**CITY OF PORTLAND  
HOUSING SAFETY OFFICE**

**Inspection Violations**

<b>Owner/Manager</b> KLEIBACKER MARJORIE		<b>Inspector</b> Jason Duval	<b>Inspection Date</b> 10/6/2017
<b>Location</b> 27 GREENLEAF ST	<b>CBL</b> 012 0001001	<b>Status</b> Violations Exist	<b>Inspection Type</b> Inspection

Back Stairway 1st to 2nd Floor

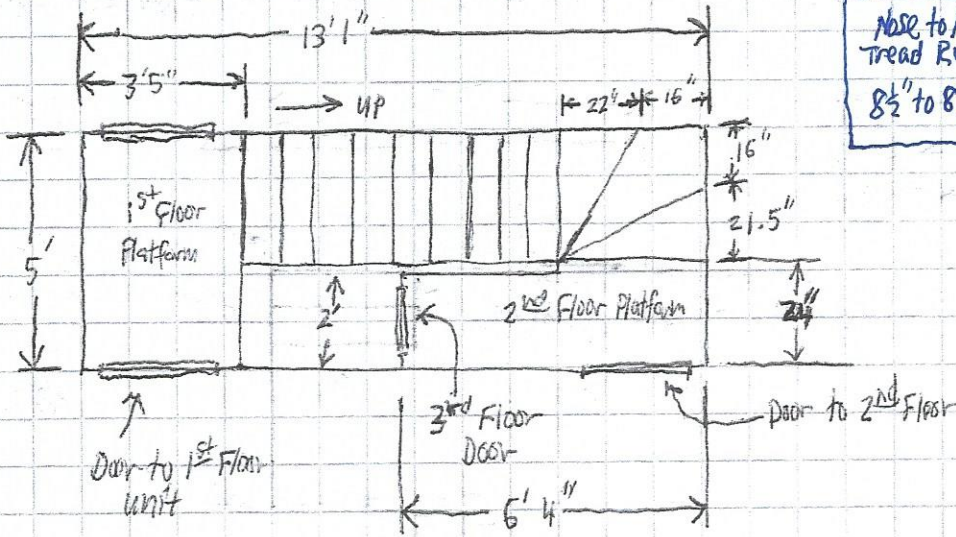
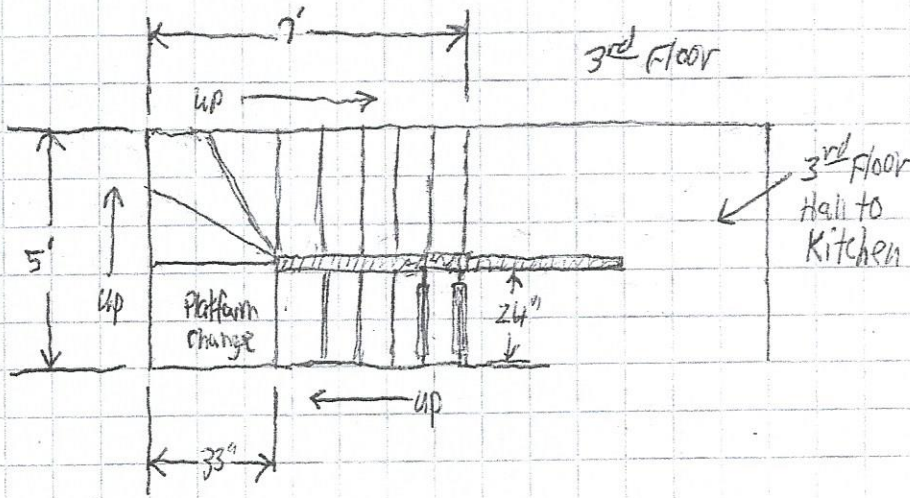
**Notes:** Remove debris from back stairwell.
